CITY OF ALBUQUERQUE

RE: **Juan Tabo Hills Estates**
Revised Grading Plan
Engineer's Stamp Date: 7/12/18
Hydrology File- M21D018; DRB# 1005278

Based on the submittal received on 7/20/18, the revised grading plan cannot be approved until the following are corrected:

SEE SHEET 5 OF 10

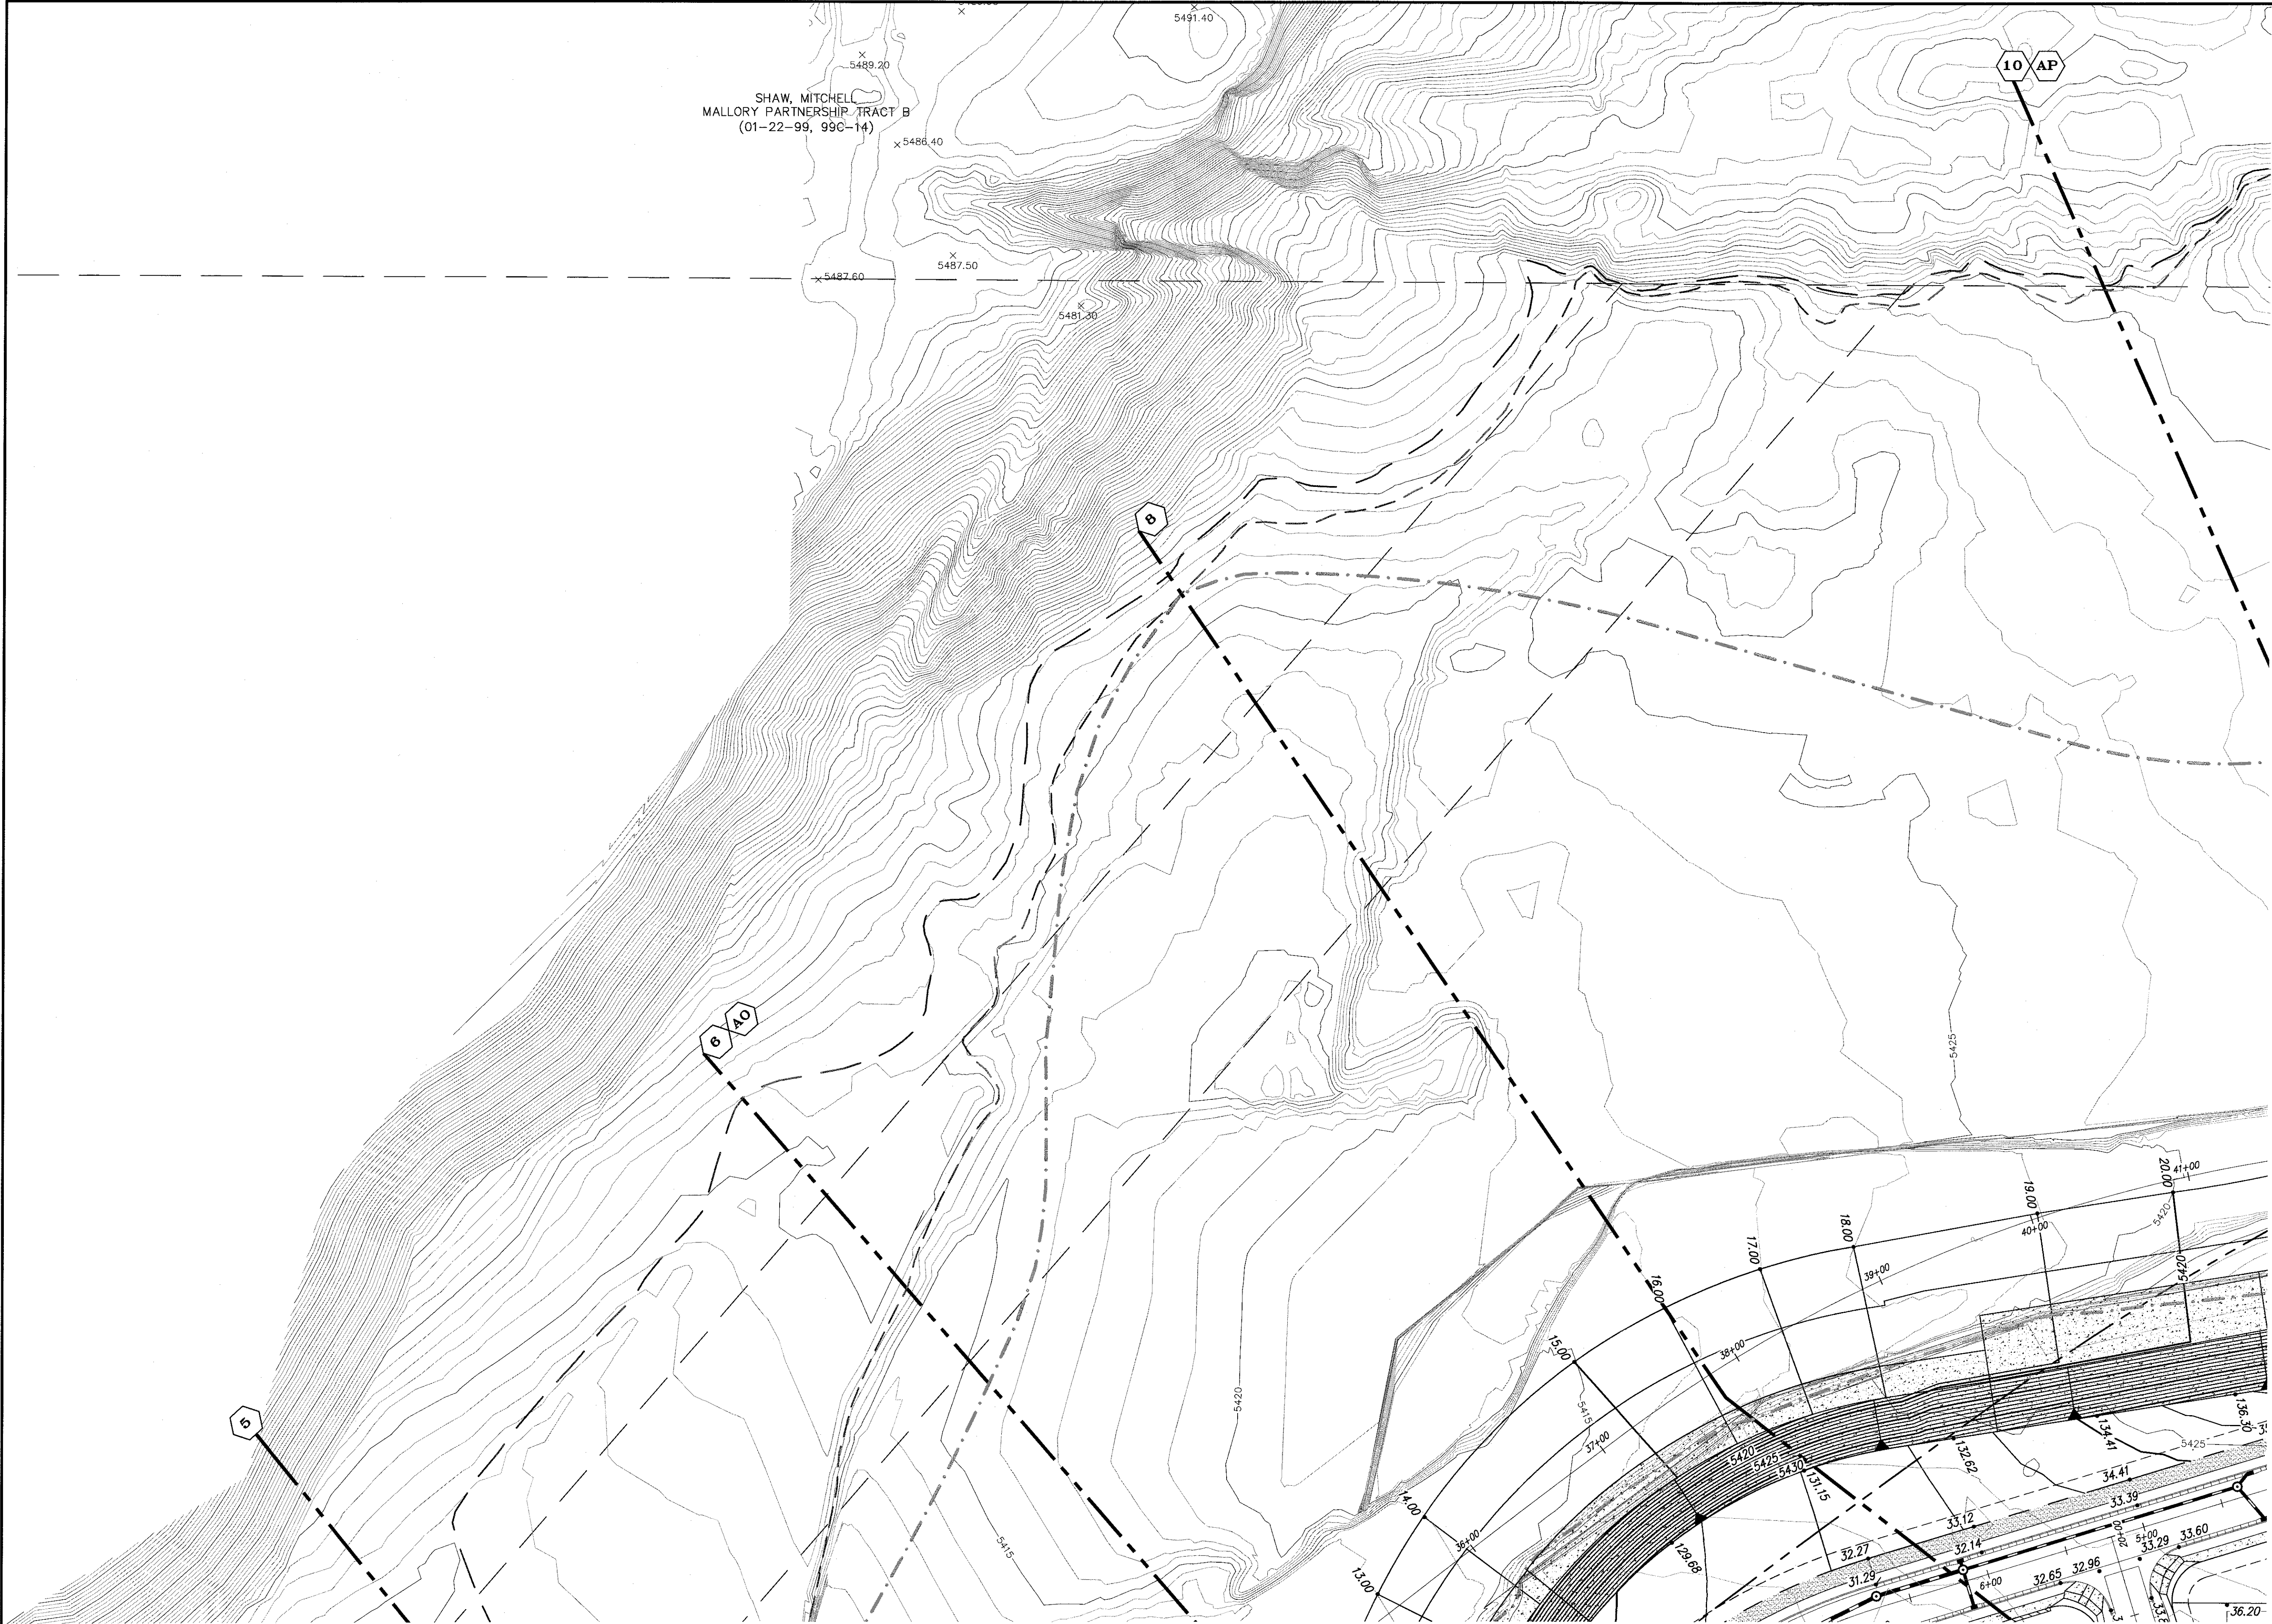
1. Fill in or provide an armored drainage conveyance for the low spot south of the Rocky Top entrance. This area cannot be allowed to pond adjacent to the road embankment:

2. Provide the sections shown on the grading plan.
3. Provide an armored drainage conveyance for the interspaces between the terraced retaining walls and down into the storm water pond; ensure the AMAFCA access road is protected from this runoff:

4. Please verify that the AMAFCA maintenance ramp, gate, and retaining walls are consistent with the current bank protection plans:

5. Provide self-ponding areas in the interspace (park) between the AMAFCA access road and the public road. The contours and spot elevations should reflect the access road as sloping at 2% away from the top of shotcrete and back into the park area. The ponding areas should be sized for the 10-day, 100-yr volume with supporting calculations provided.
6. This plan proposes lot adjustments and changes to the approved grades in excess of 18" and within 50' of the property line (vicinity Lot16, Block13). The amended preliminary plat will require Development Review Board approval (Hydrology approval of the revised grading plan will be a pre-requisite of the amended plat):

7. Many of the Lots have been re-numbered. Is this intentional? This will need to be updated on the amended preliminary plat as well. Look at: Block 19, Block 14, Block 13,
8. Lot 8(?) of Block 12 is not labeled. Lot 6(?) of Block 4 is not labeled. Lot 6(?) and Lot 7(?) of Block 2 are not labeled.
9. The pads for: Lot 1- Block 14, Lot 1- Block 15, Lot 16- Block 9, encroach into the ROW; please correct.
10. Explain the switch to the dual pipe penetration at the SW pond. Is this reflected in the bank protection plans? Where are its build notes? It is still labeled as a single 48" pipe. The grading for the AMAFCA access ramp should be shown here as well as the grades for the emergency spillway:

11. Will this pond still function as a first flush facility? If not, than payment of the Fee-in-Lieu will be required at a rate or \$6/cf for the SWQ volume.
12. Provide rip-rap armoring at the outside bend of Sandia Sunset. If water surcharges out of the NMDOT inlet upstream near MH-47, flows will travel overland down Sandia Sunset and will likely jump the curb at this bend:

13. Hydrology recommends putting the prudent line for the Tijeras Arroyo on this grading plan if desiring to obtain Pad Certifications prior to acceptance of the bank protection. Otherwise the prudent line will need to be added on each Pad Certification.
